**Gunnedah Waste Facility (SSD-8530563)
Response to Submissions**

ATTACHMENT 1

DRAWING TITLE				
SWEEP PATH ANALYSIS PLAN - B DOUBLE				
PROJECT NO.	PLANSET NO.	RELEASE NO.	DRAWING NO.	REVISION
P1907434	PS01	R16	PS01-GZ10	L

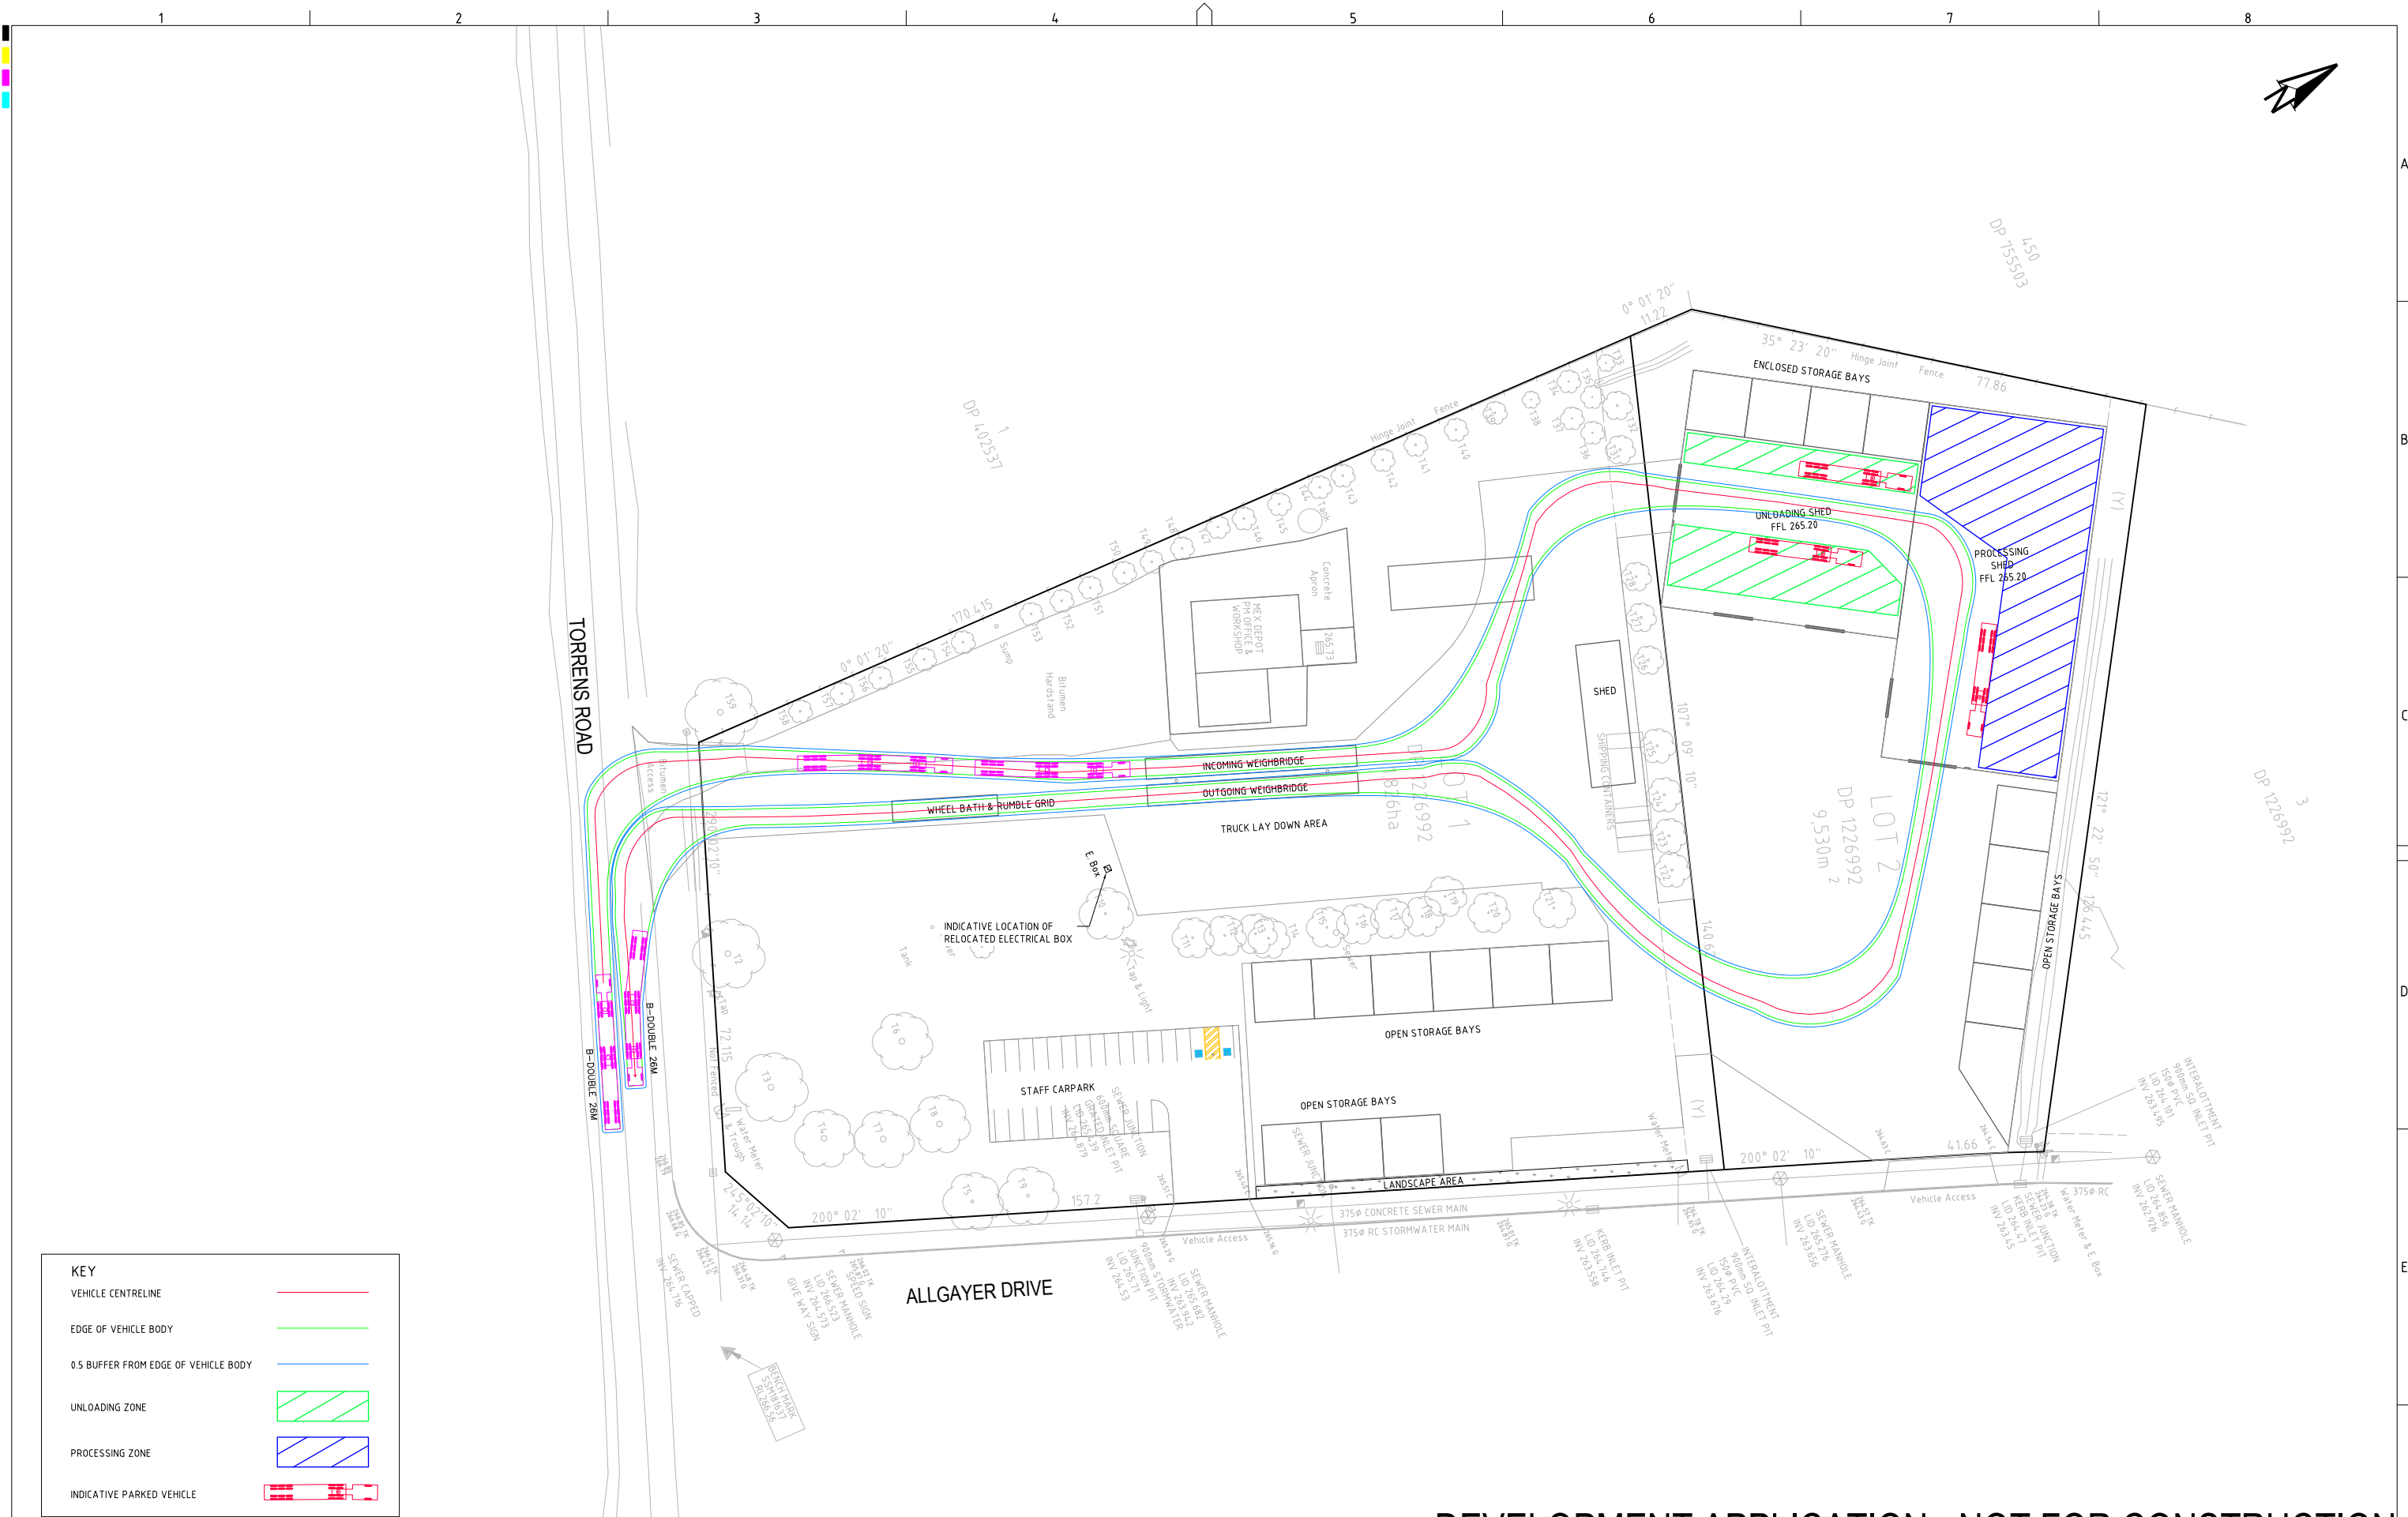
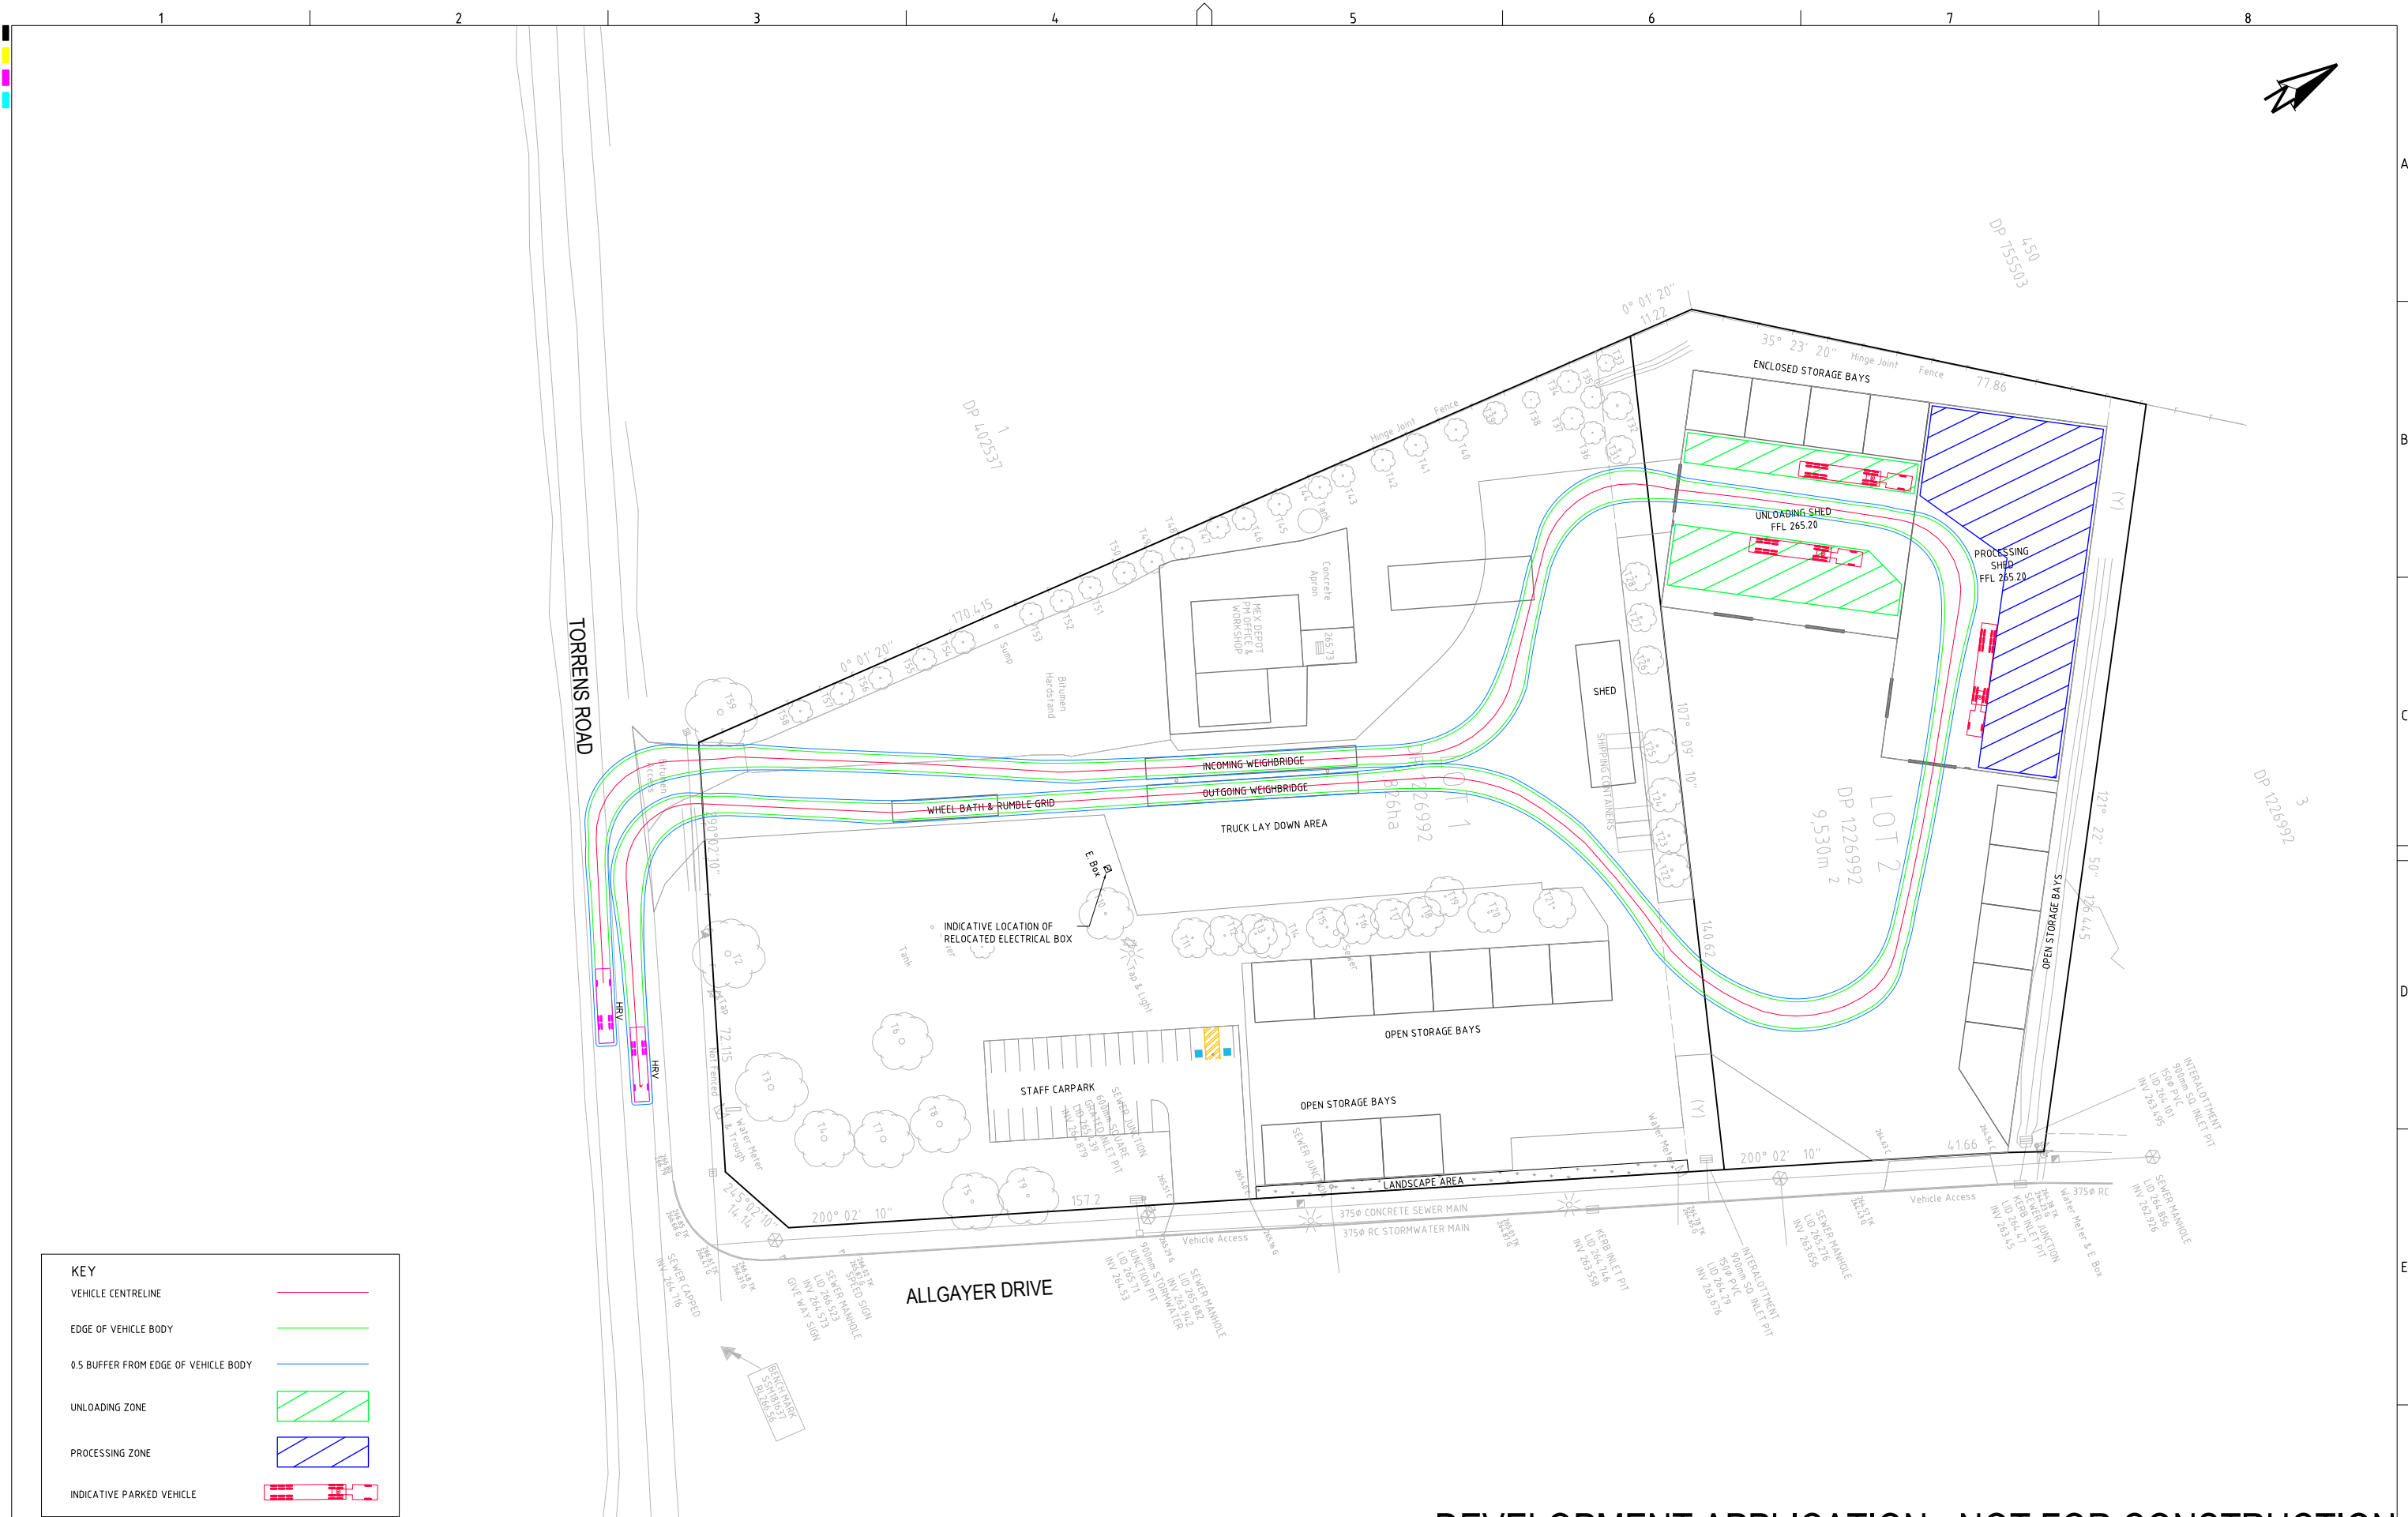
- Confirm the largest vehicle expected to enter the site and provide swept paths for this vehicle. Please provide swept path diagrams showing vehicles exiting the site onto Torrens Road.

- Describe how site traffic will be managed when a B double or B triple (as shown in swept path diagrams) is turning right to enter the site as other vehicles would not be able to exit simultaneously based on the current width of the driveway.
